Our ref: OUT22/997

14 March 2022

Re: Western Coal Services (SSD 5579) – Mod 4 EA

Detailed advice to DPE Planning & Assessment regarding the Western Coal Services (SSD 5579) – Mod 4 EA

Figure 1: Modification 4 Elements

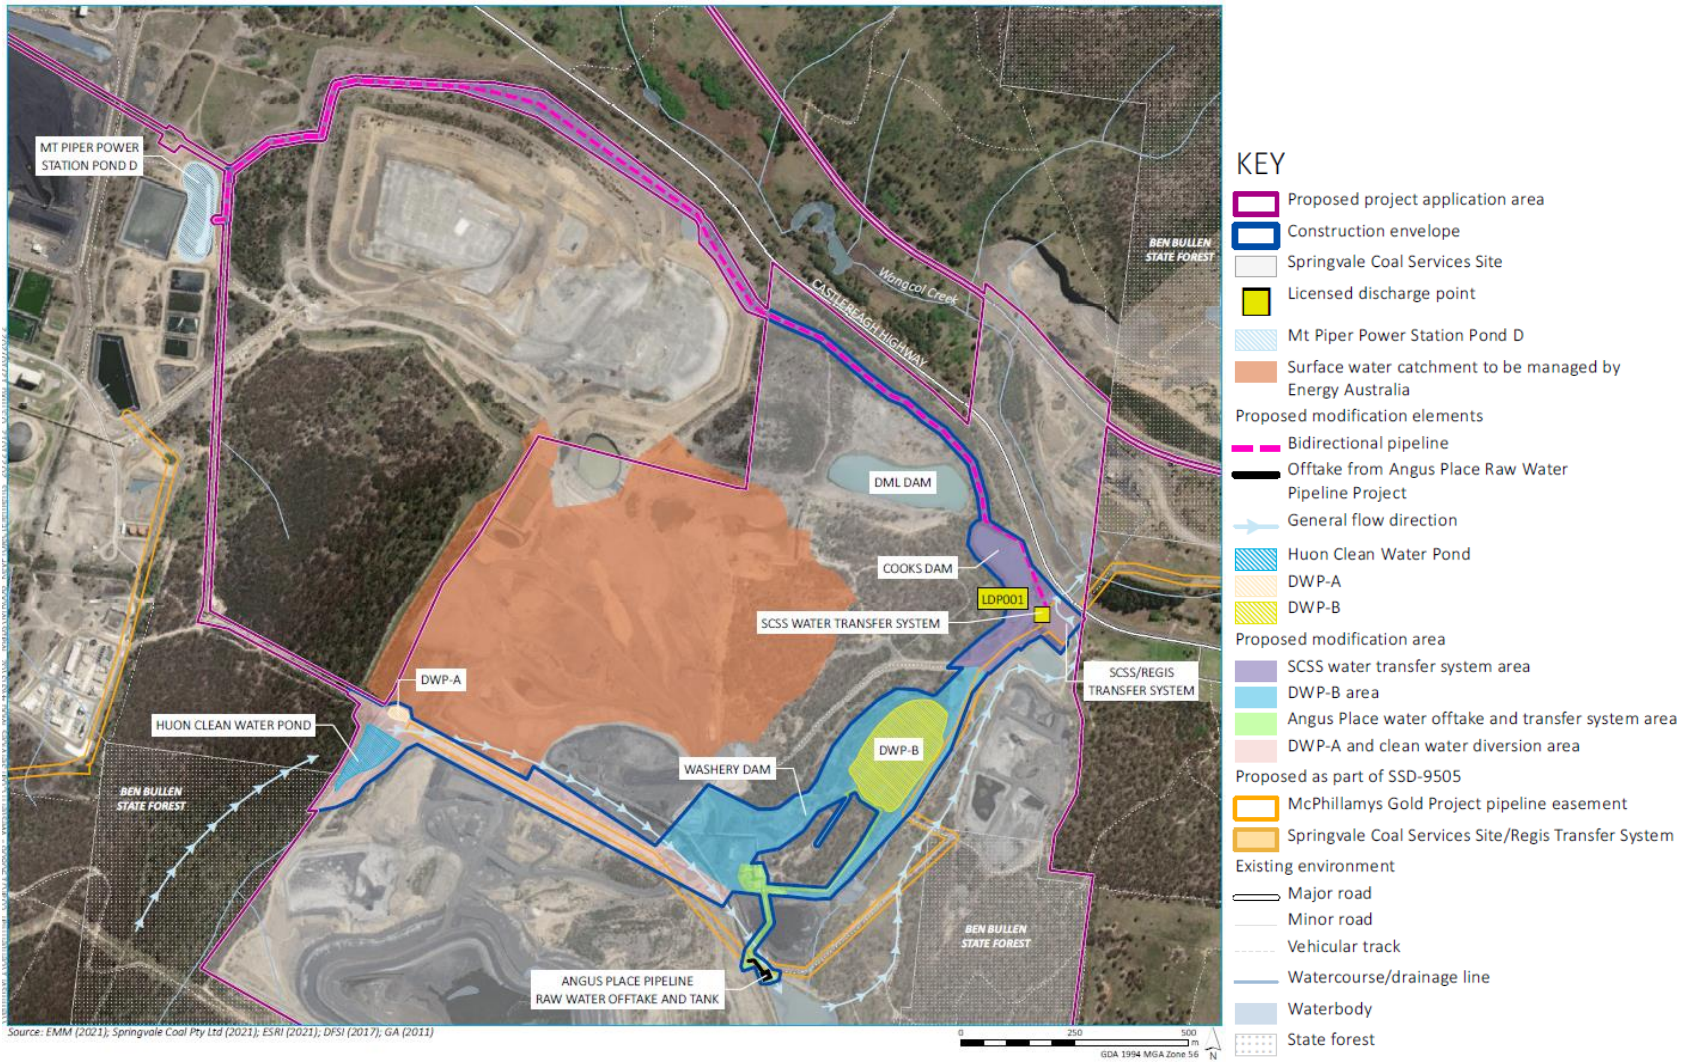
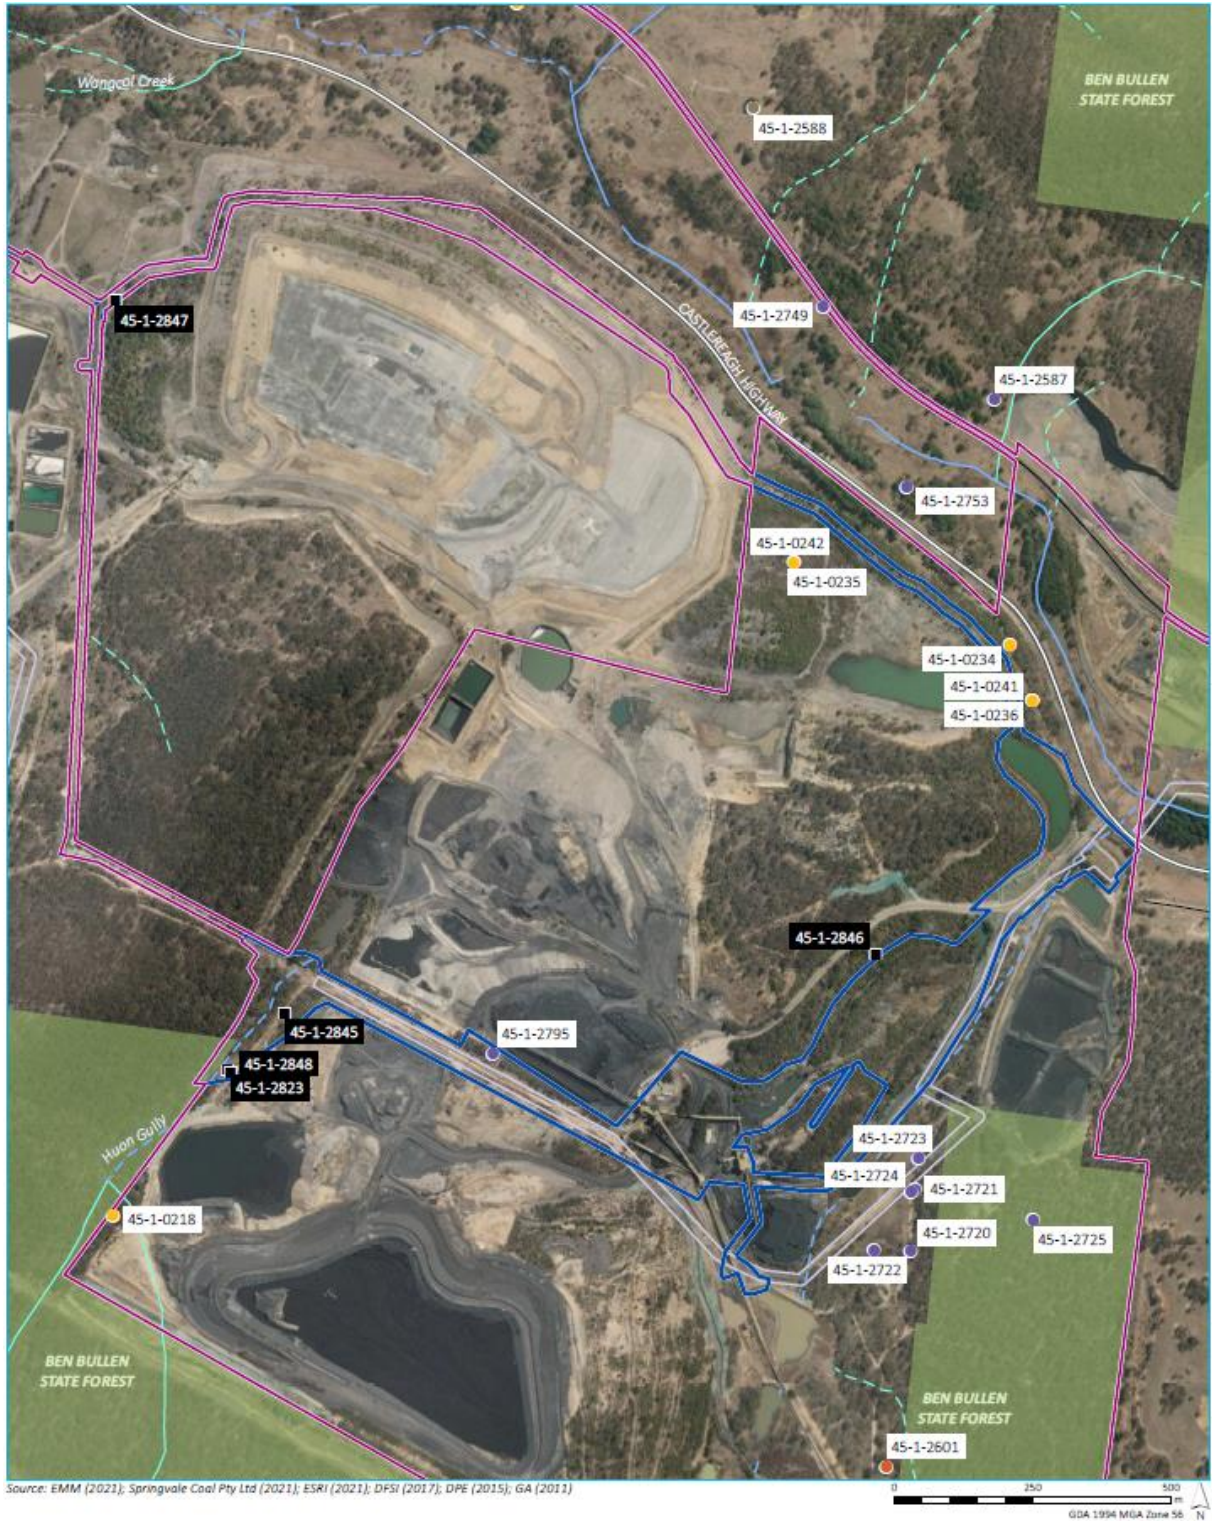
- 2.1** The proponent should clarify the clean and dirty water storages and management associated with the proposed diversion of clean water from Huon Gully CWP into Lamberts Gully and release into Wangcol Creek. It is recommended clean water be separated from dirty water.

Clarification is requested of the effectiveness of the proposed clean water diversion from the Huon Gully Clean Water Pond (CWP) to the Lamberts Gully clean water system and the influence of dirty water storages. This is due to Figure 5.4 of the report depicting the Huon CWP as a dirty dam and the Main Sediment Basin where the water is to be diverted to as a clean dam. Further to this, water in the Main Sediment Basin is described in the report as requiring settling time before discharge which suggests it is a dirty water dam. If the water diverted from the Huon CWP is clean, NRAR recommends that it be diverted directly into a clean section of Lamberts Gully.
